08 April 2019

D2016/1529/C - RESPONSE TO COUNCIL RFI

BASEMENT 2 - HOTEL BOH & RESIDENTIAL DROP OFF

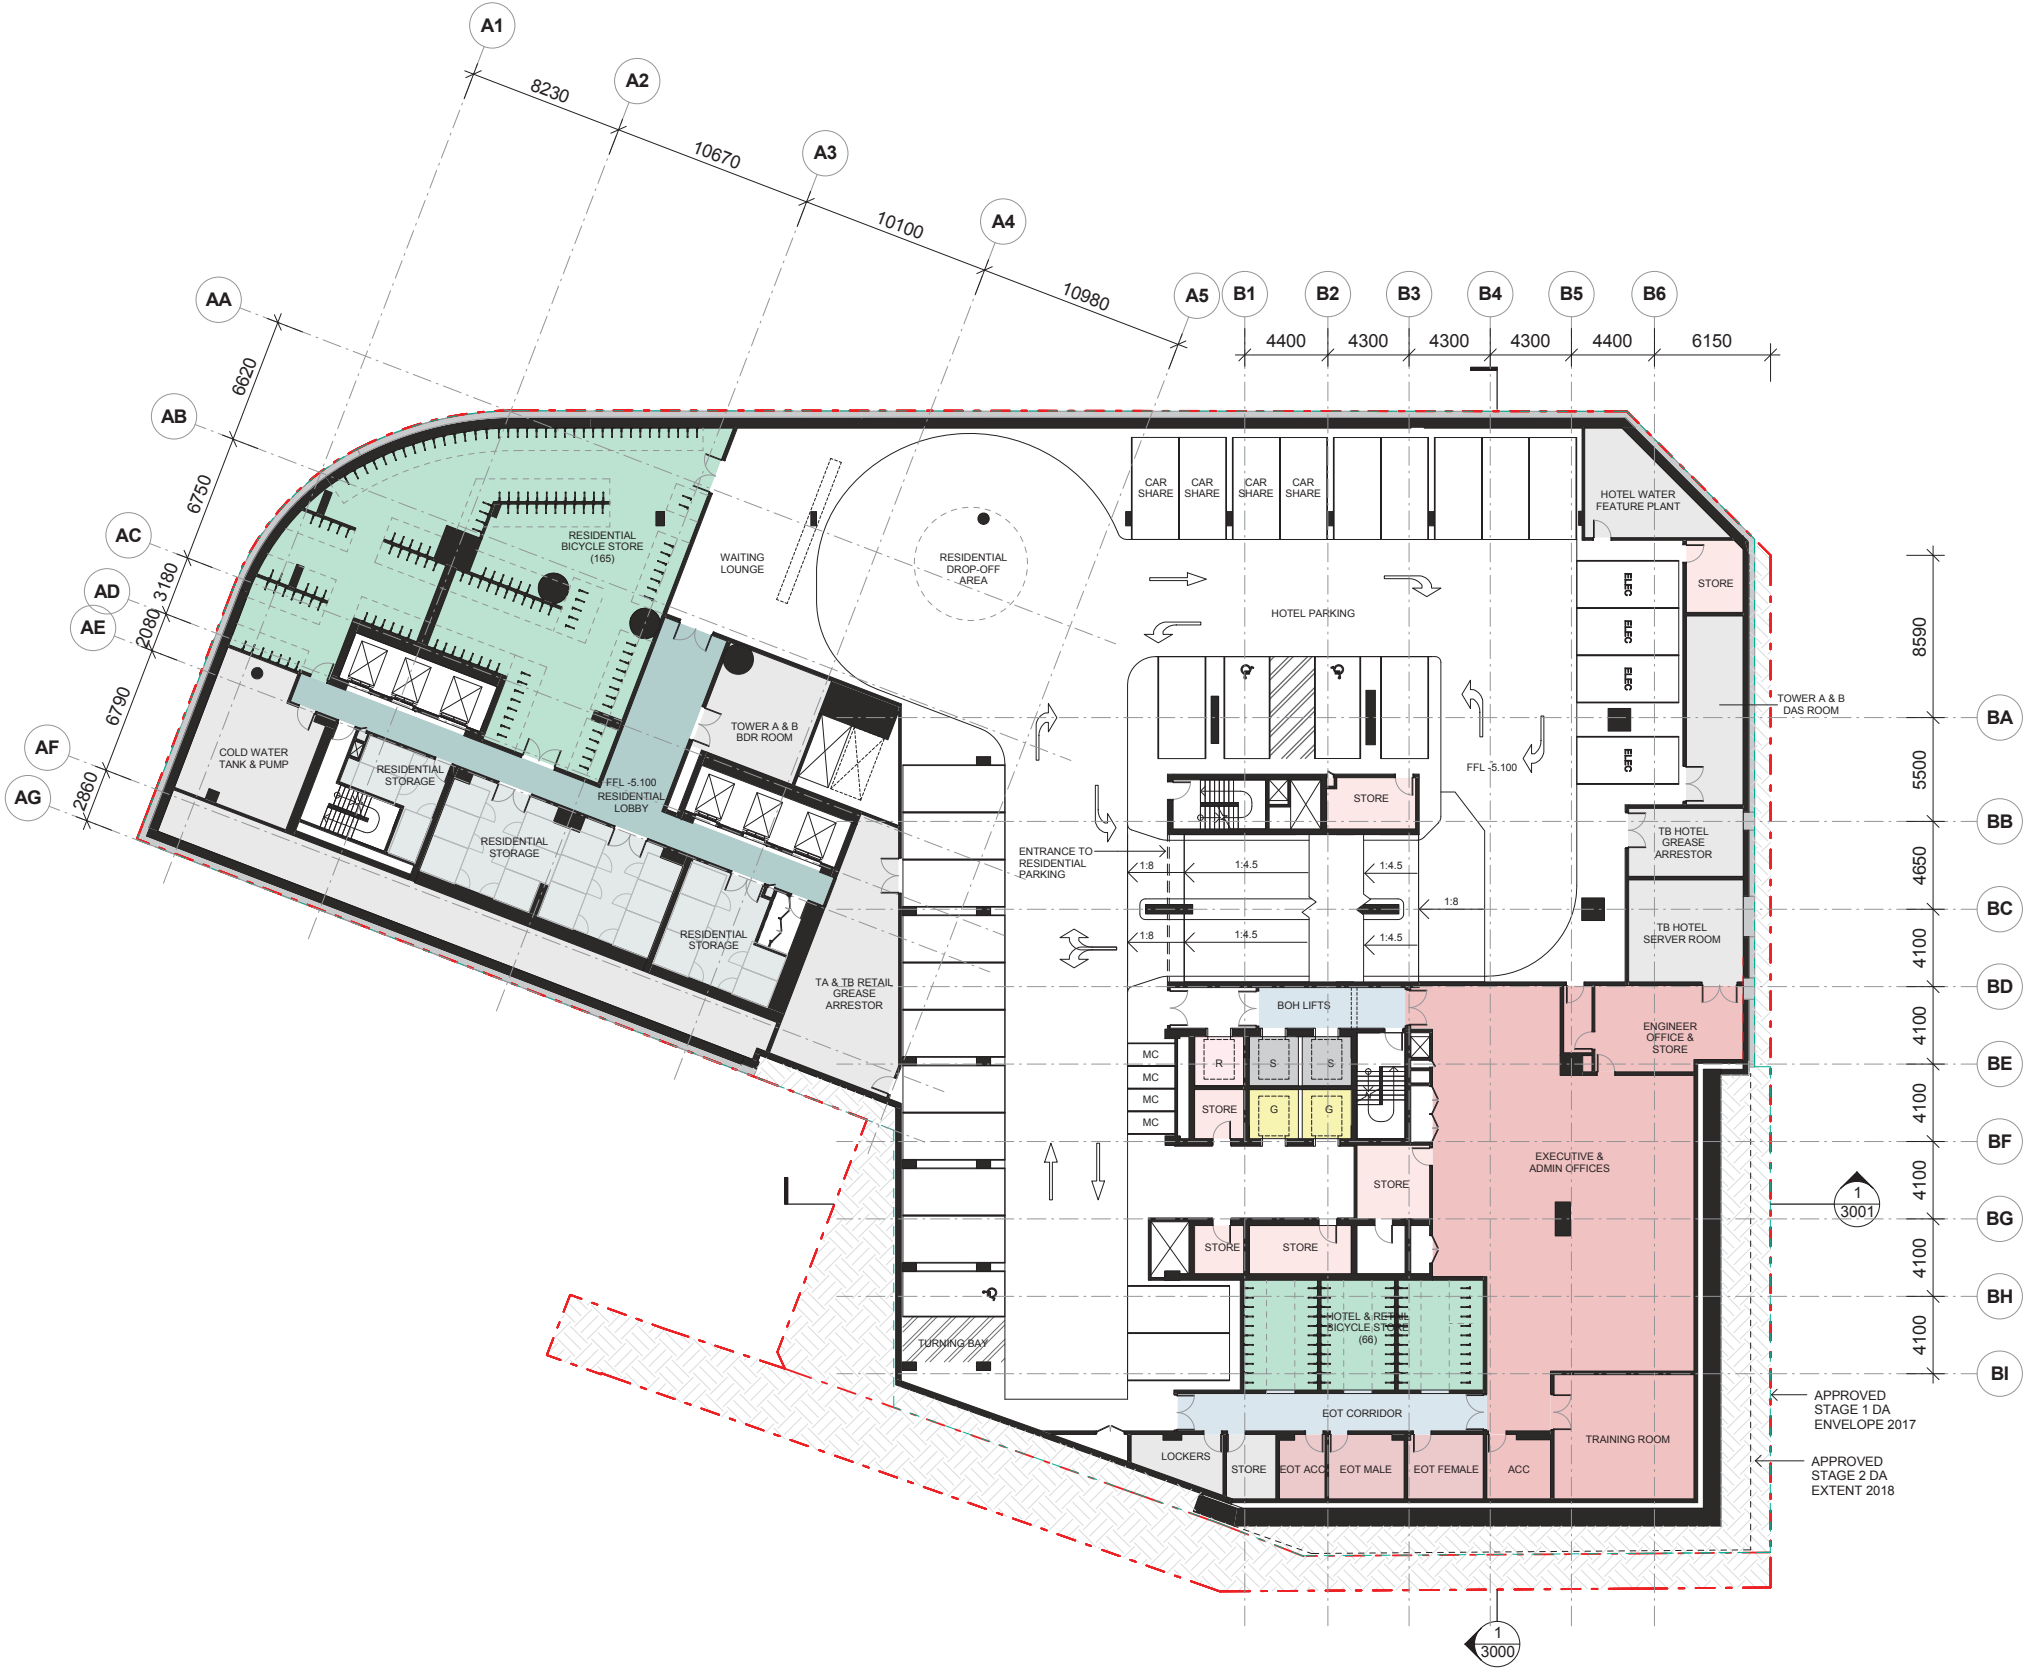
Matter	Council Comment	Response
Flooding	1. The PMF level along Pitt Street basement ramp is 3.97mAHD. The proposed fire stair has an access to the basement 1 however, the floor level/ threshold level of this fire egress is unknown.	The fire stair configuration has been revised and is included within the amended plan at Attachment 1 .

Partial Wall Section

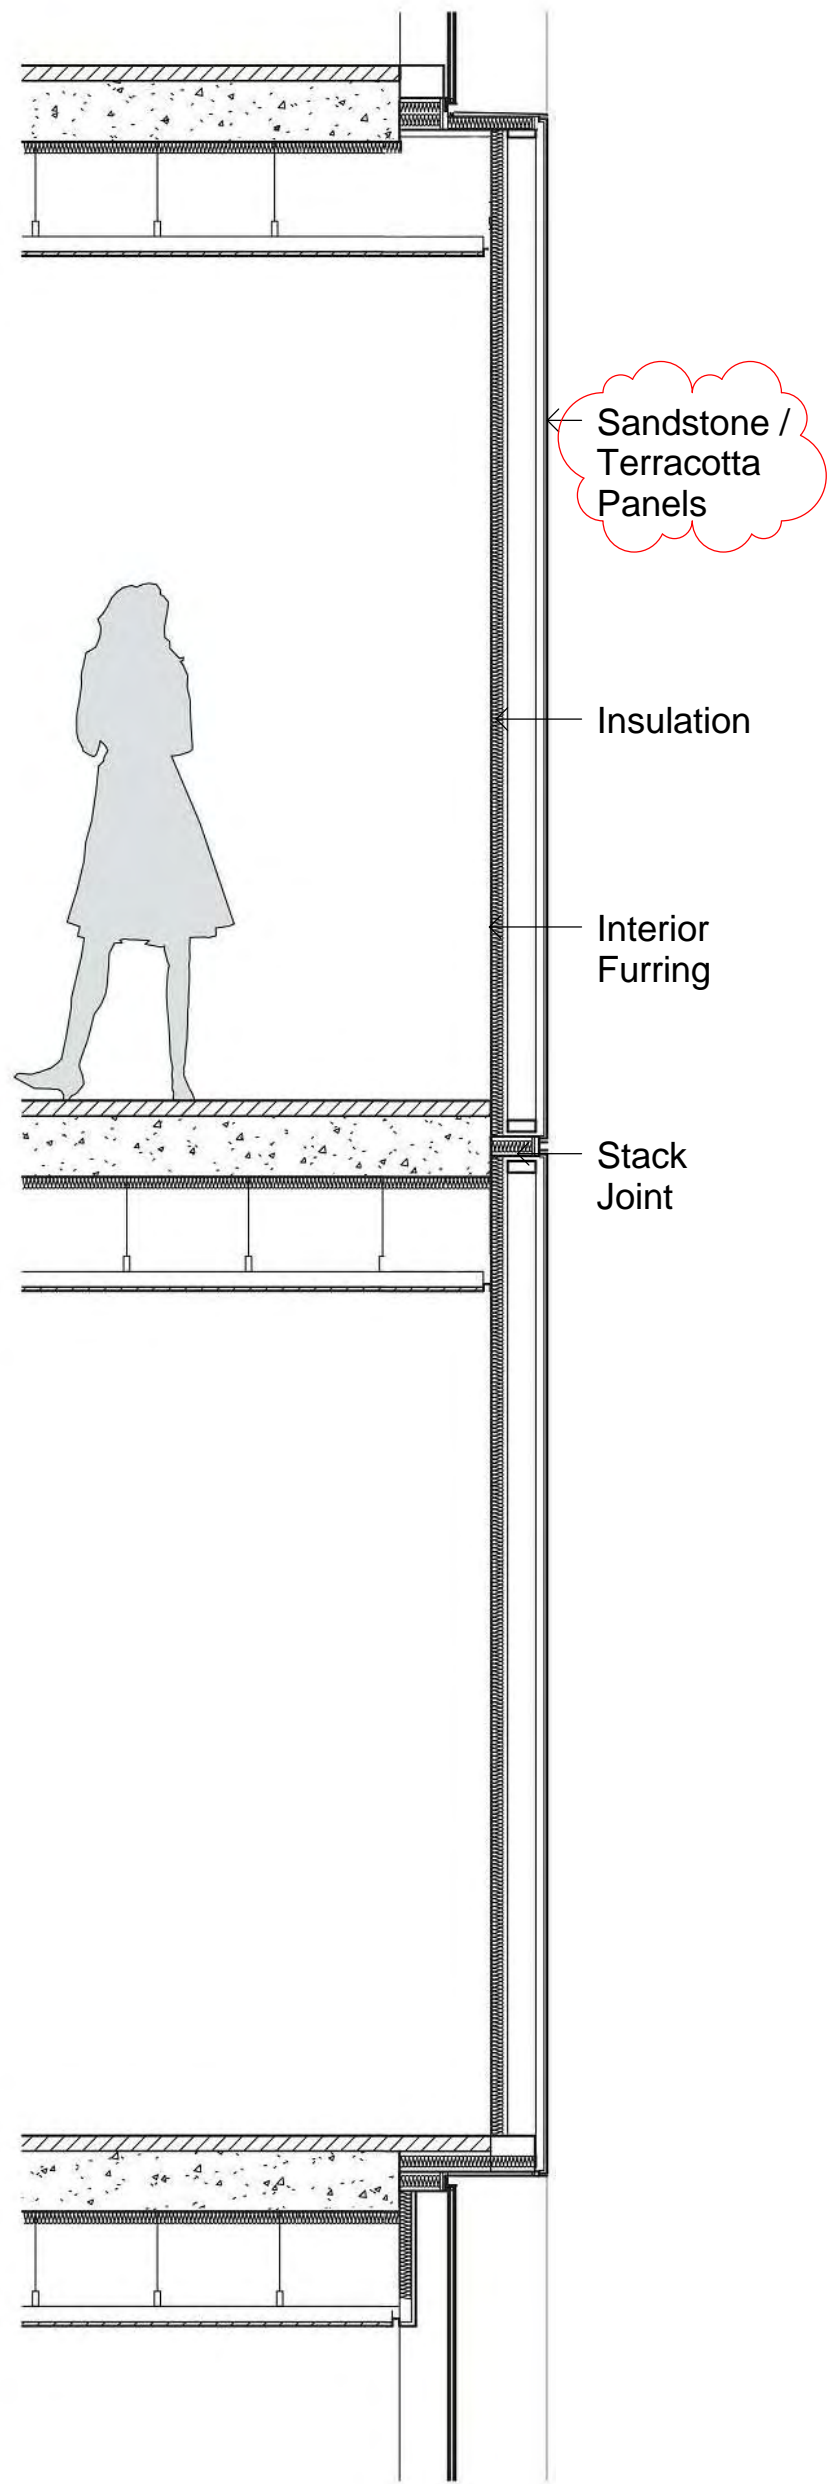
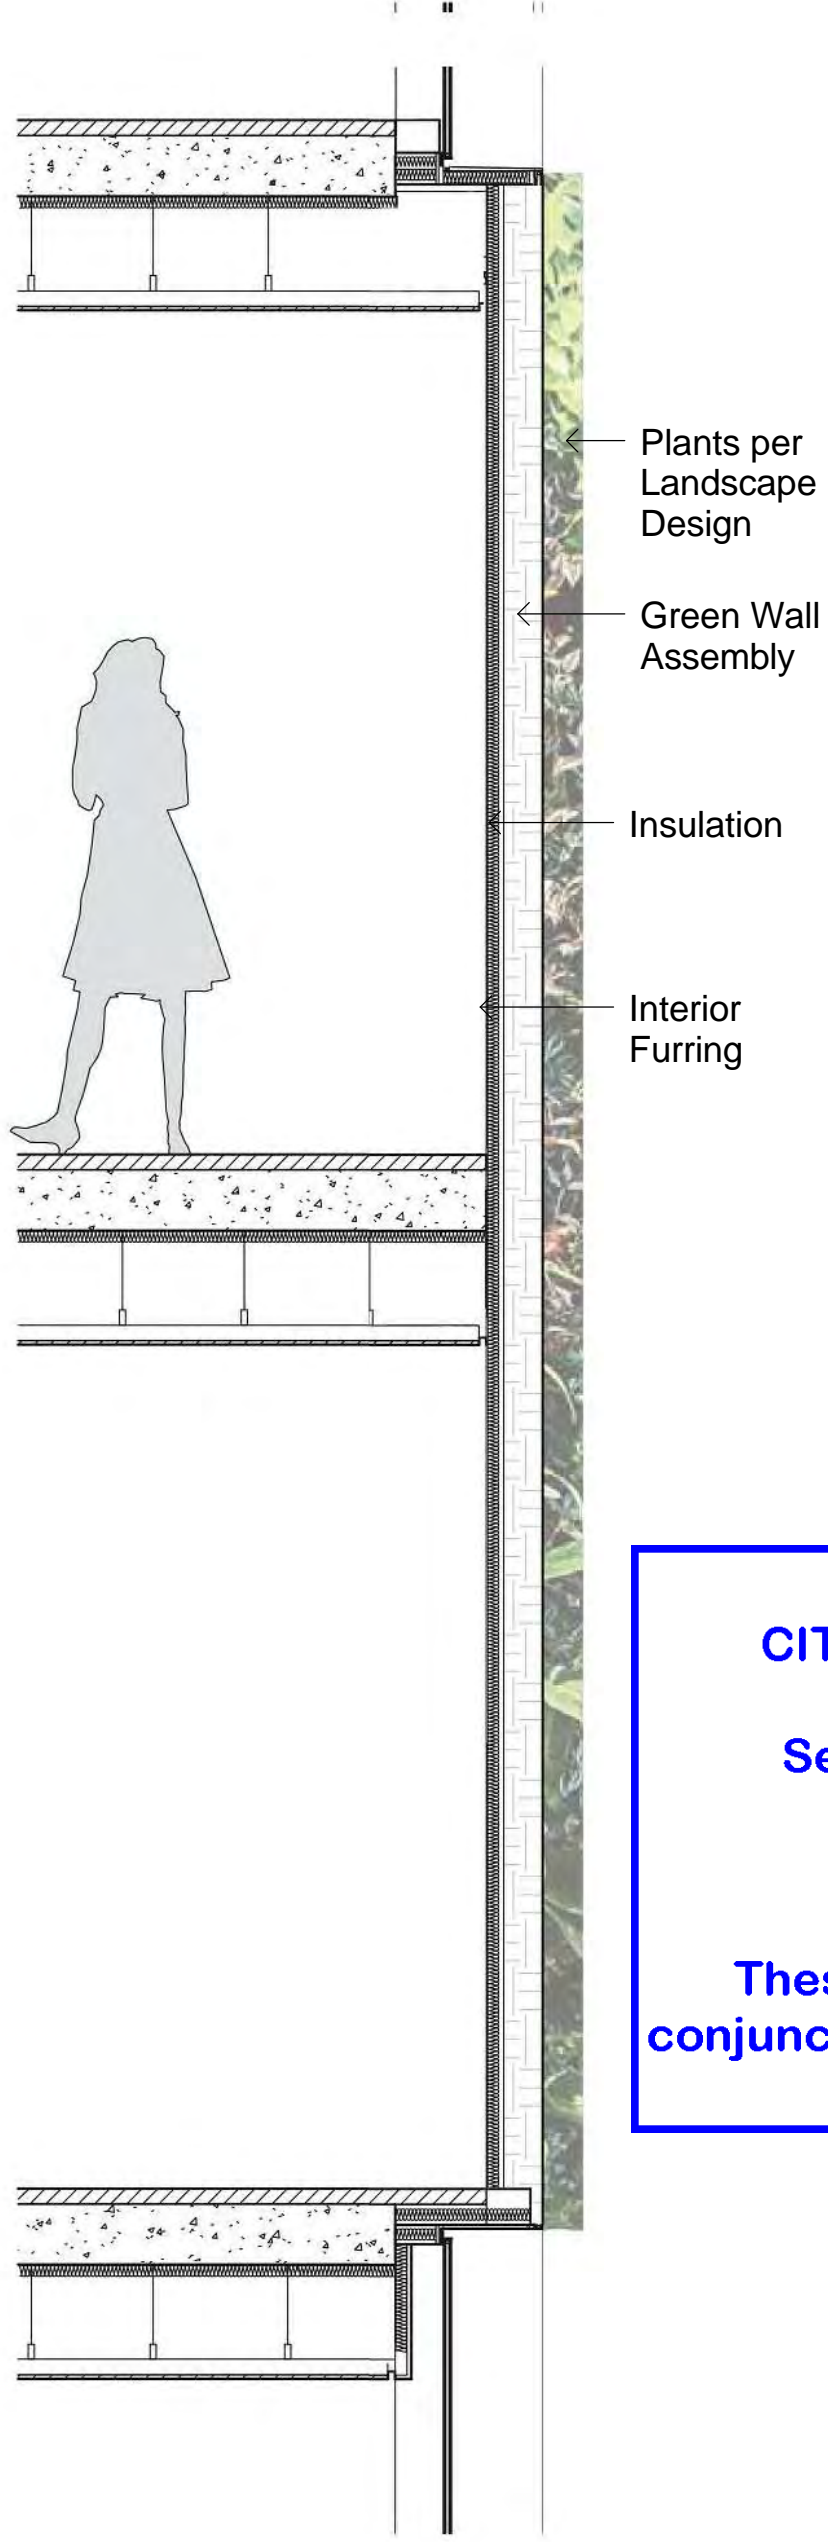
2. It is important that the top of the ventilation grilles are not visible above the building facades. A detailed section (scaled 1:50 that could be stamped, if approved) should be provided to demonstrate that the visual impact of the ventilation is minimised in so far as possible.	Please refer to Sketch provided at Attachment 1 which demonstrates that the ventilation grilles are to be located below the façade / parapet, which will be invisible from the street level.
